**REGULATION 4 OF THE INFRASTRUCTURE PLANNING (CHANGES TO, AND REVOCATION OF, DEVELOPMENT CONSENT ORDERS) REGULATIONS 2011
APPLICATION TO MAKE A NON-MATERIAL CHANGE TO THE OAKLANDS FARM
SOLAR PARK ORDER 2025 (SI 2025/739) AS CORRECTED BY THE OAKLANDS FARM
SOLAR PARK (CORRECTION) ORDER 2025 (SI 2025/1070)**

EN010122 – Oaklands Farm Solar Project Non-Material Change Application.

Amy Wheelton Independent Seales South Derbyshire District and Linton Division
Derbyshire County Councillor

Figure 2.09: Important Hedgerows  
Overview

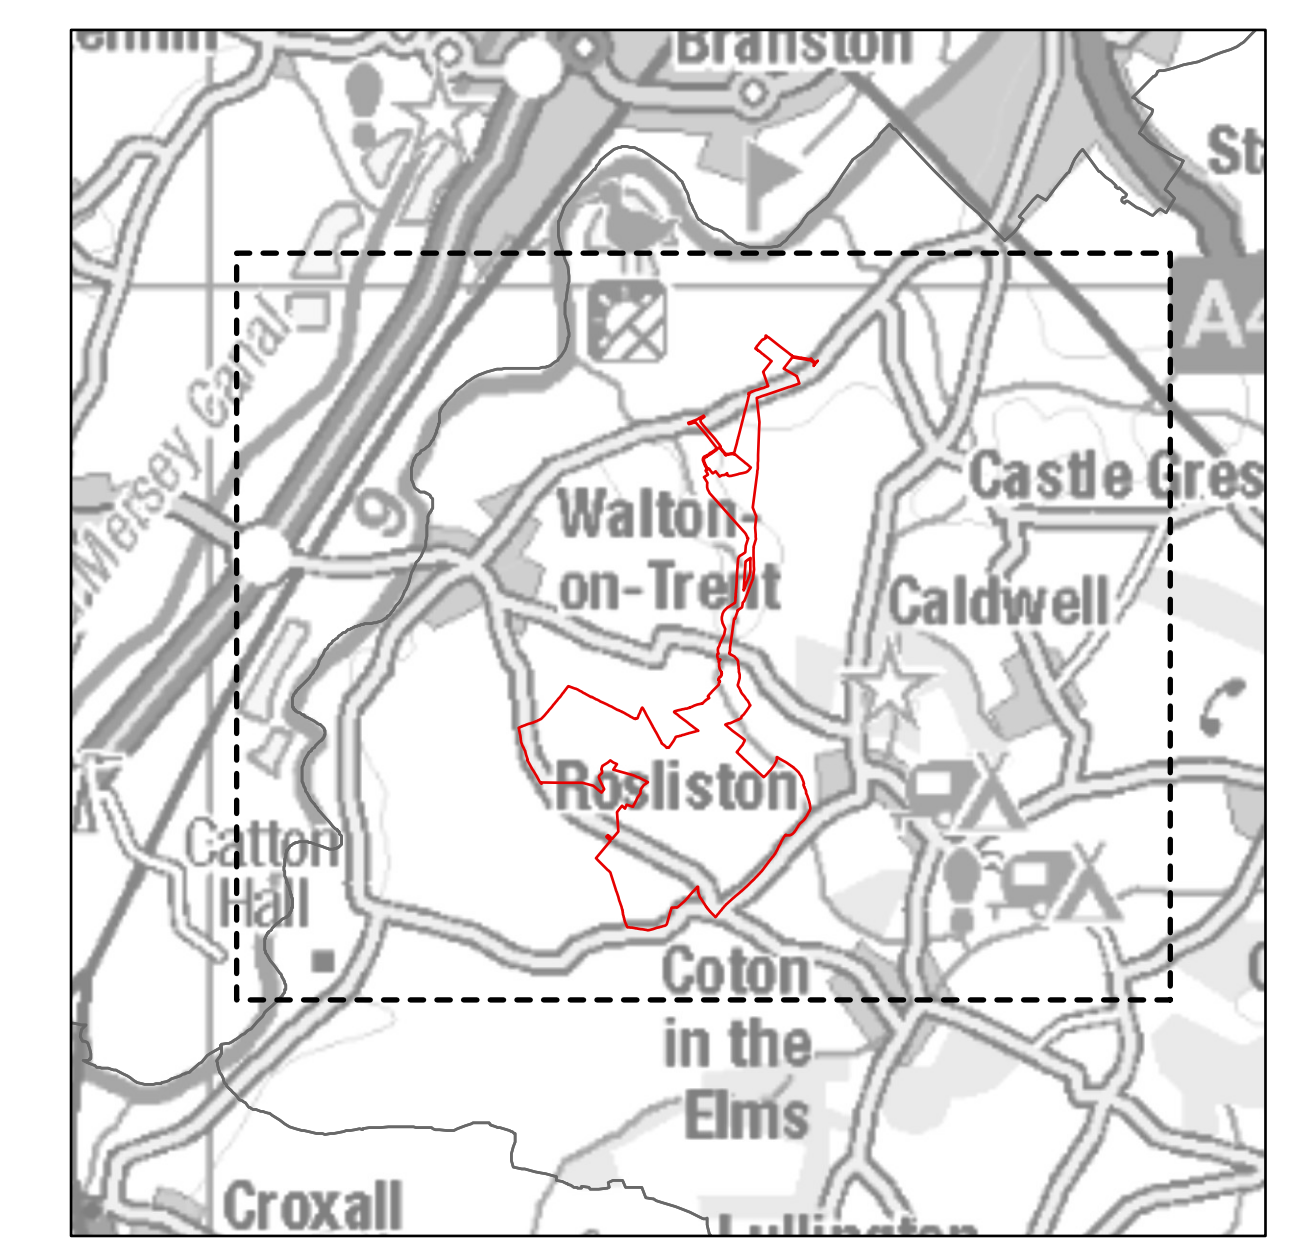
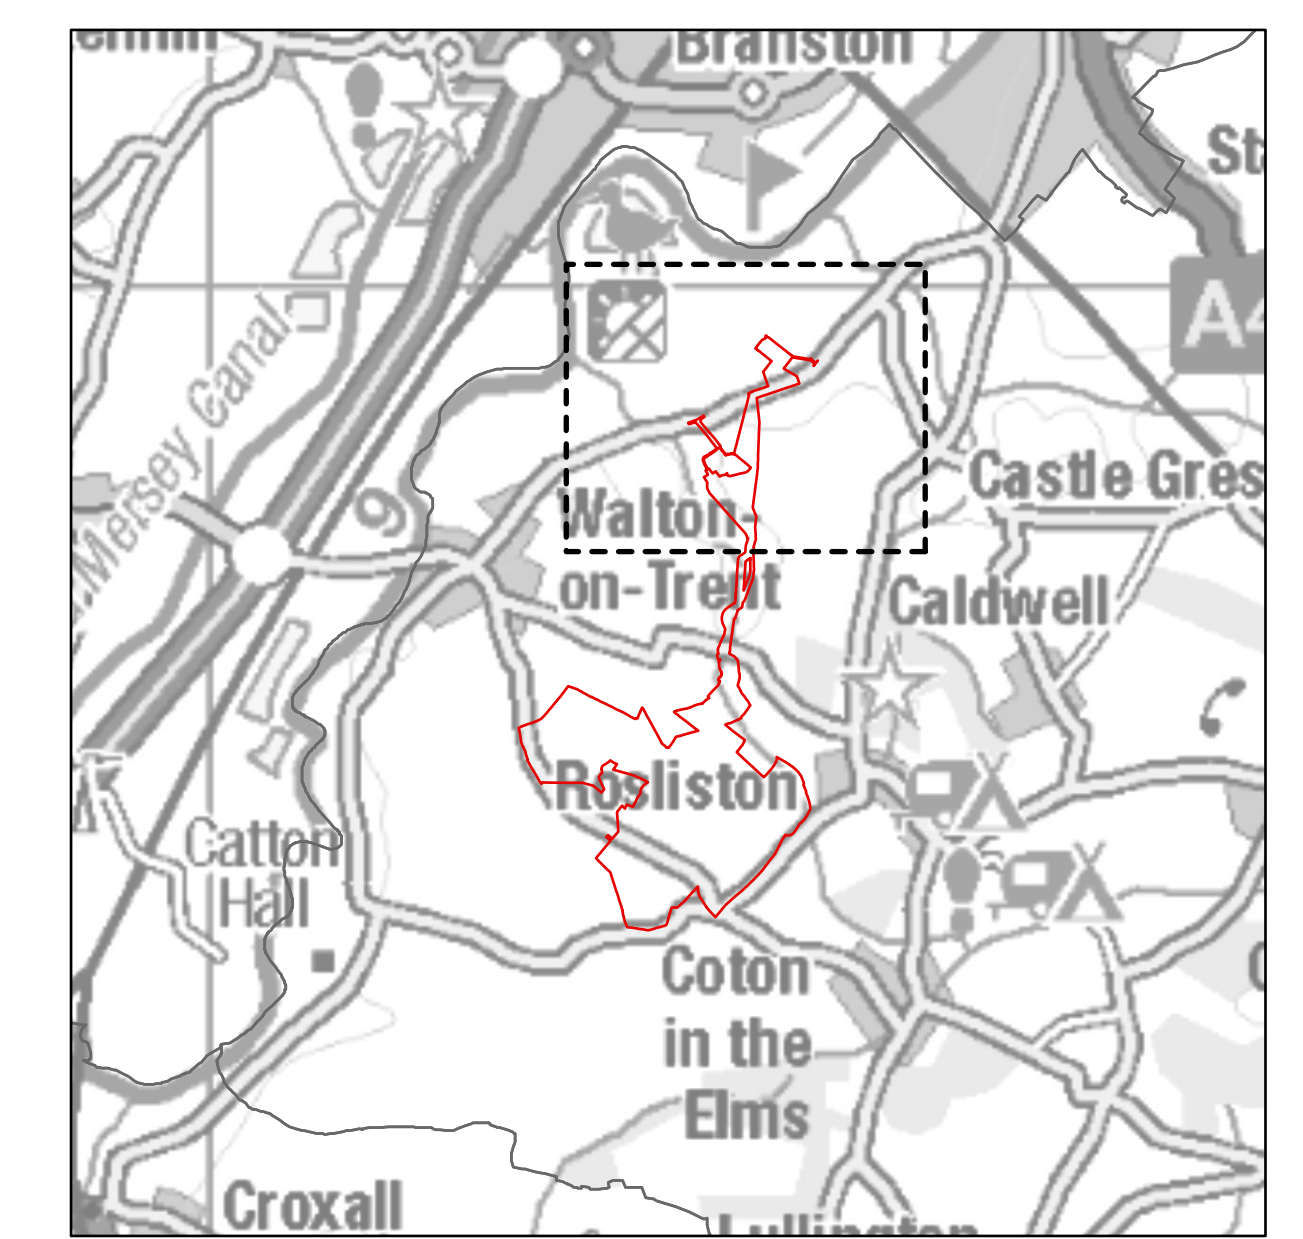
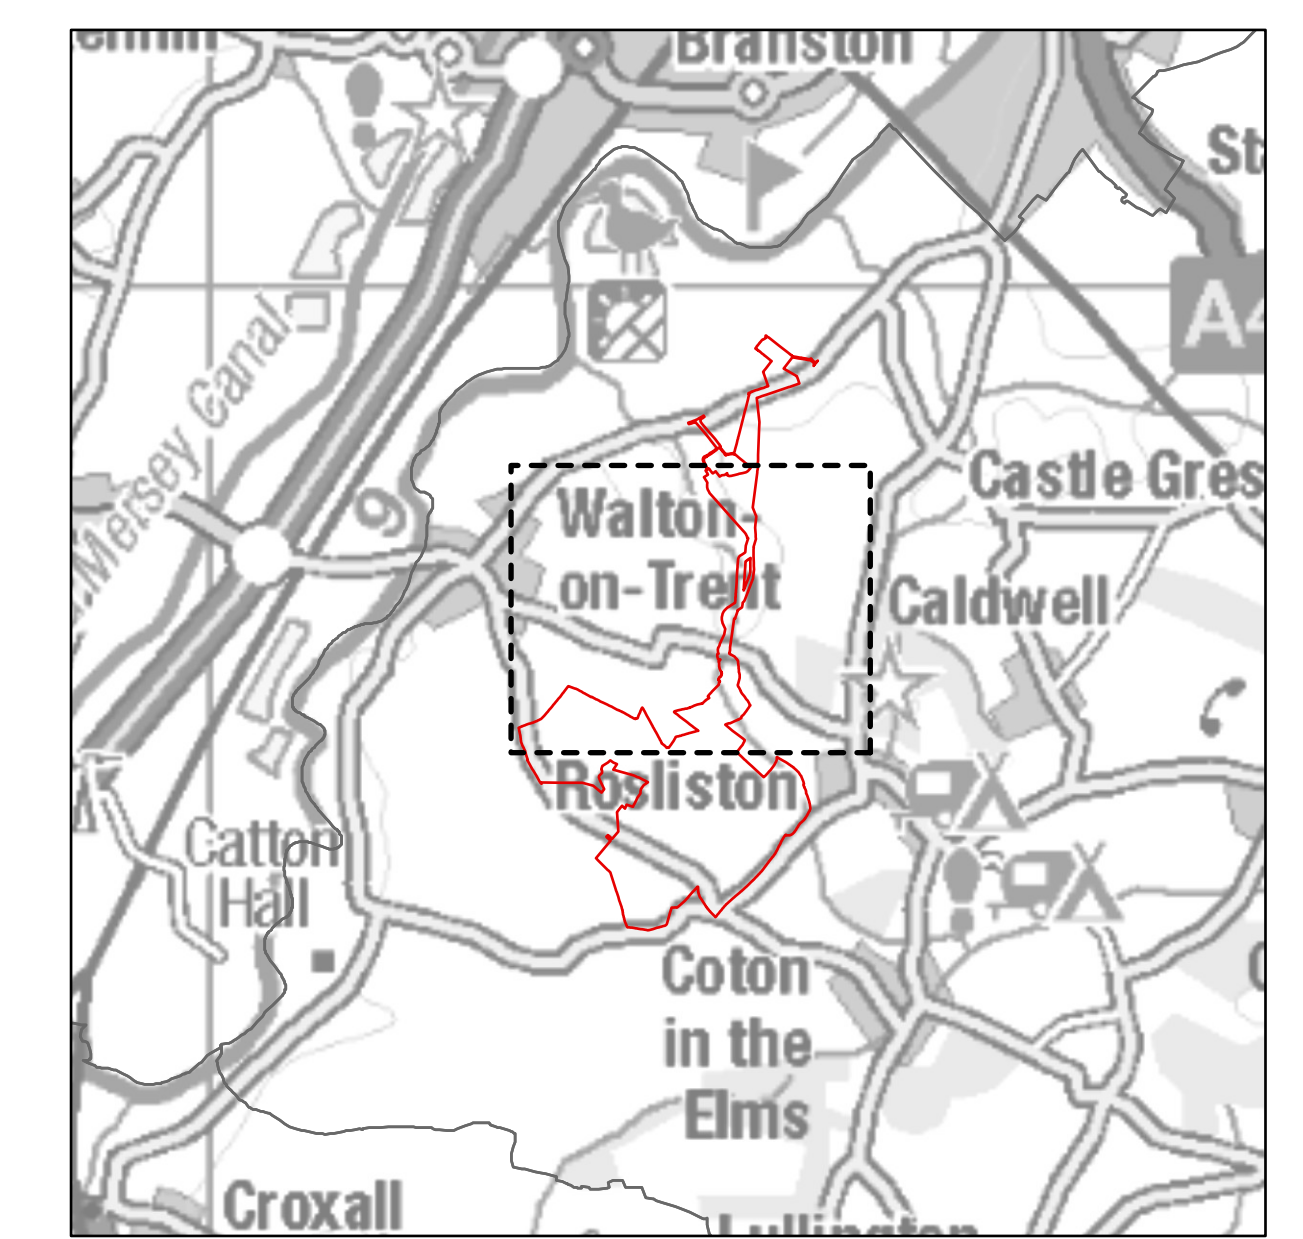
Appendix 4 - a material change from DCO increasing loss of important hedgerow from 21m to 44m by the flooded road area on Coton road.
